OXFORDSHIRE COUNTY COUNCIL'S RESPONSE TO CONSULTATION ON THE FOLLOWING DEVELOPMENT PROPOSAL

Application no: 14/01833/REM-2

Proposal: Reserved Matters to 05/01337/OUT - Details of the proposed community park adjacent to Bankside, including play, recreation, education and biodiversity features, a footpath and cycle network and other public amenities.

Transport

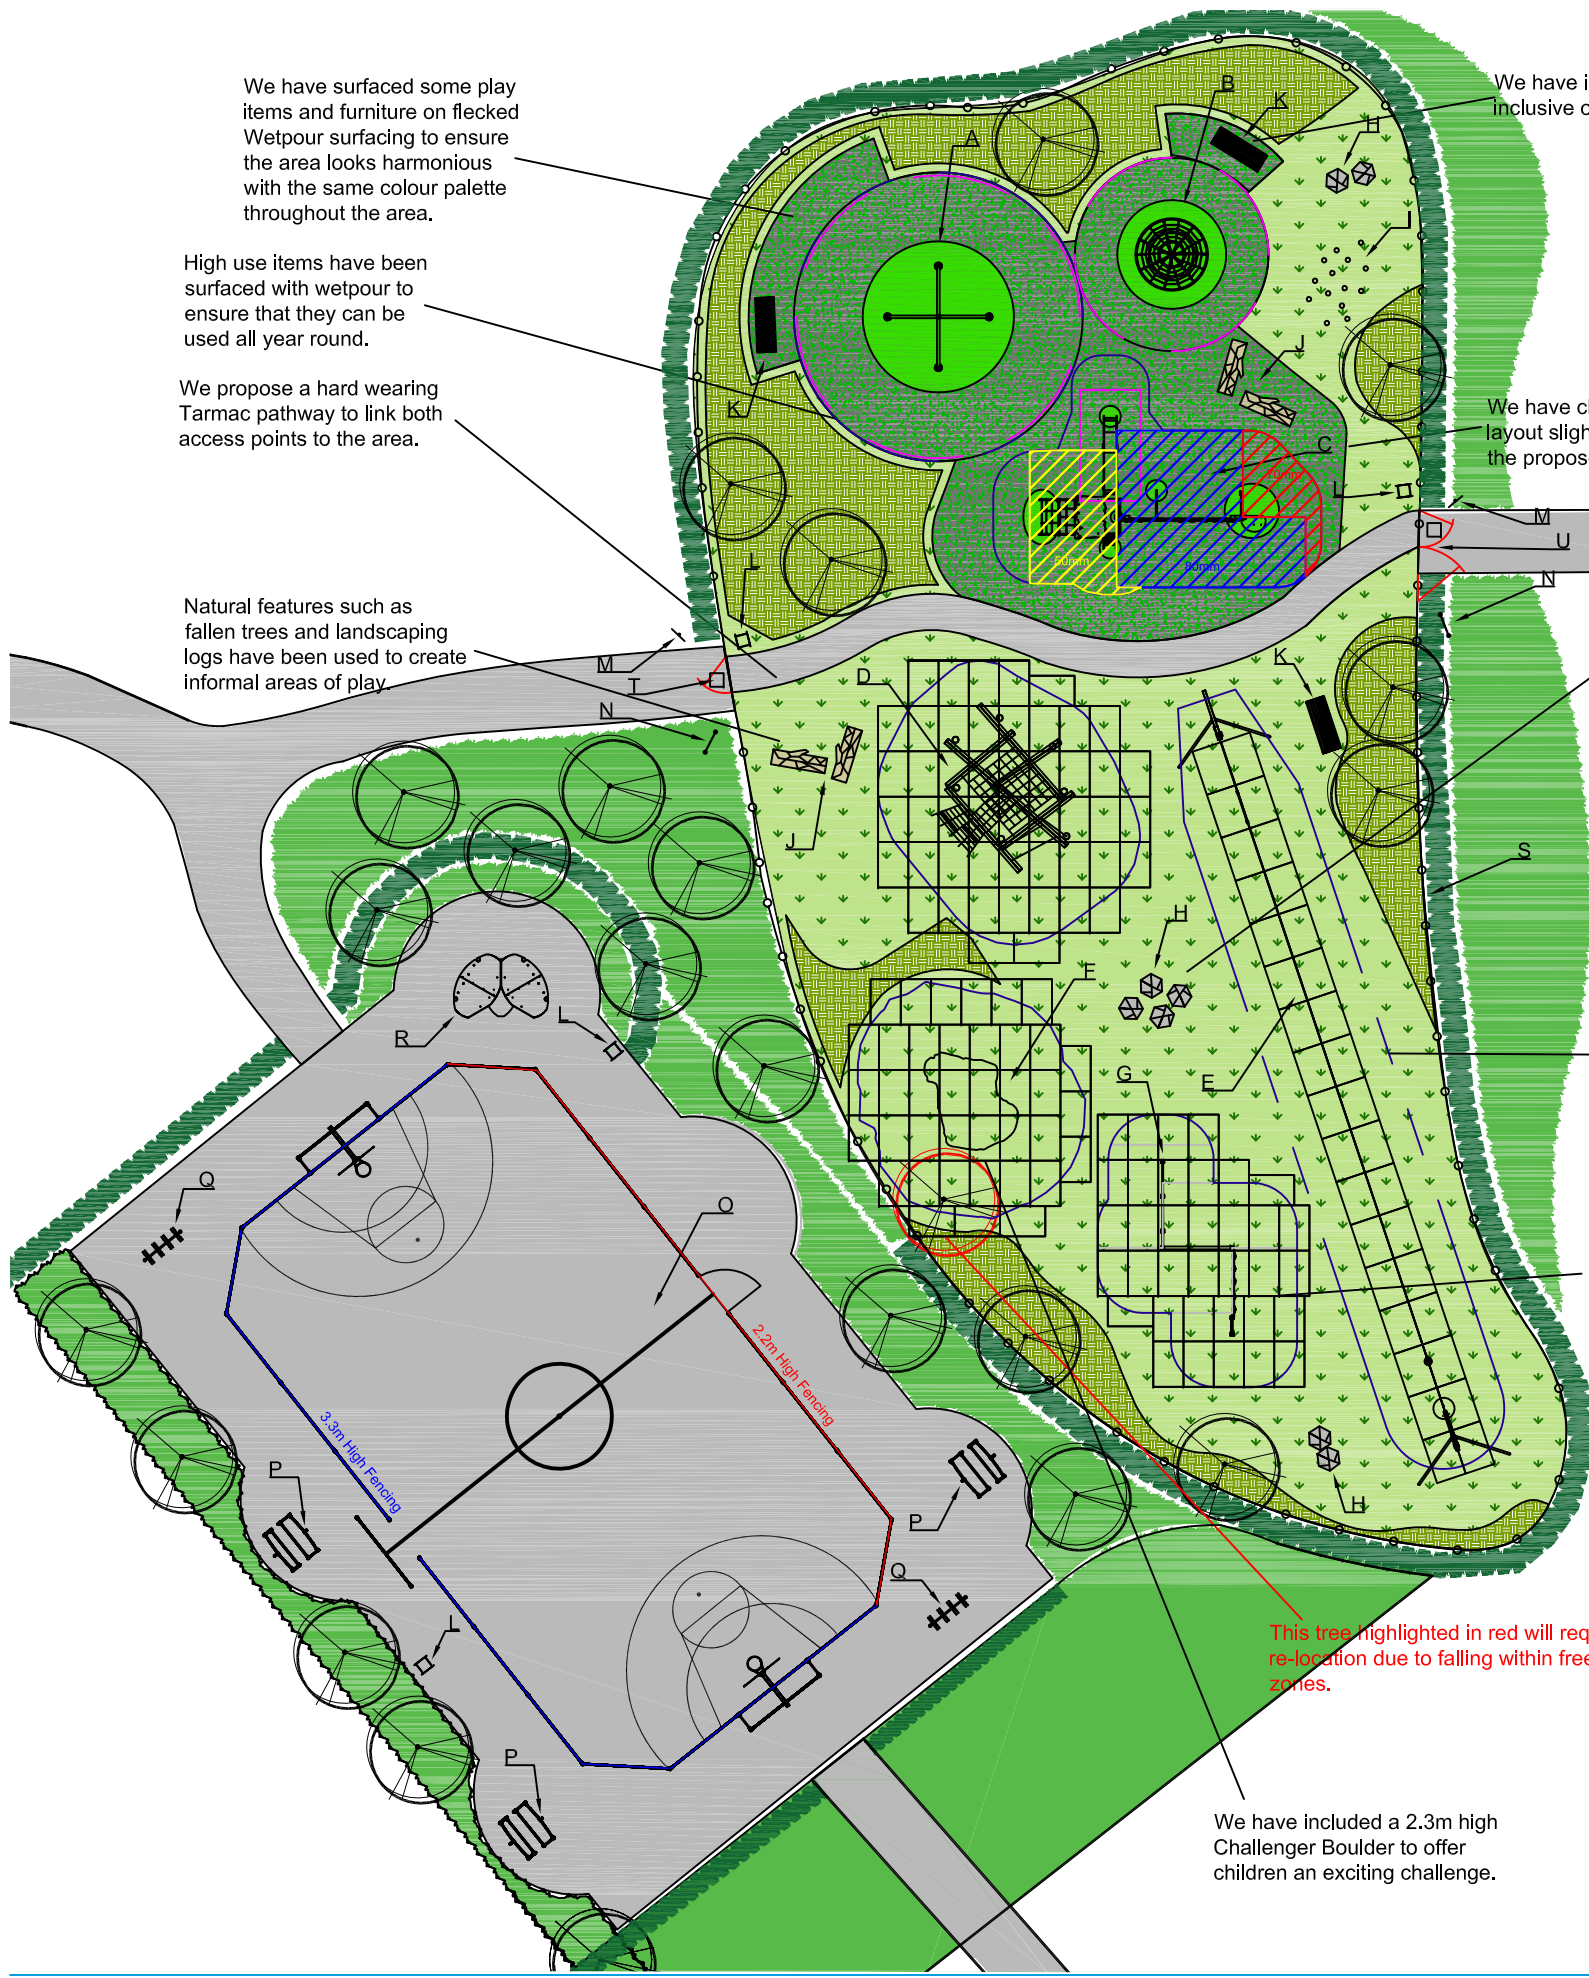
We require more details about the cycle parking that is being provided on the MUGA, which preferably are Sheffield Stands that are at a distance of 900mm apart.
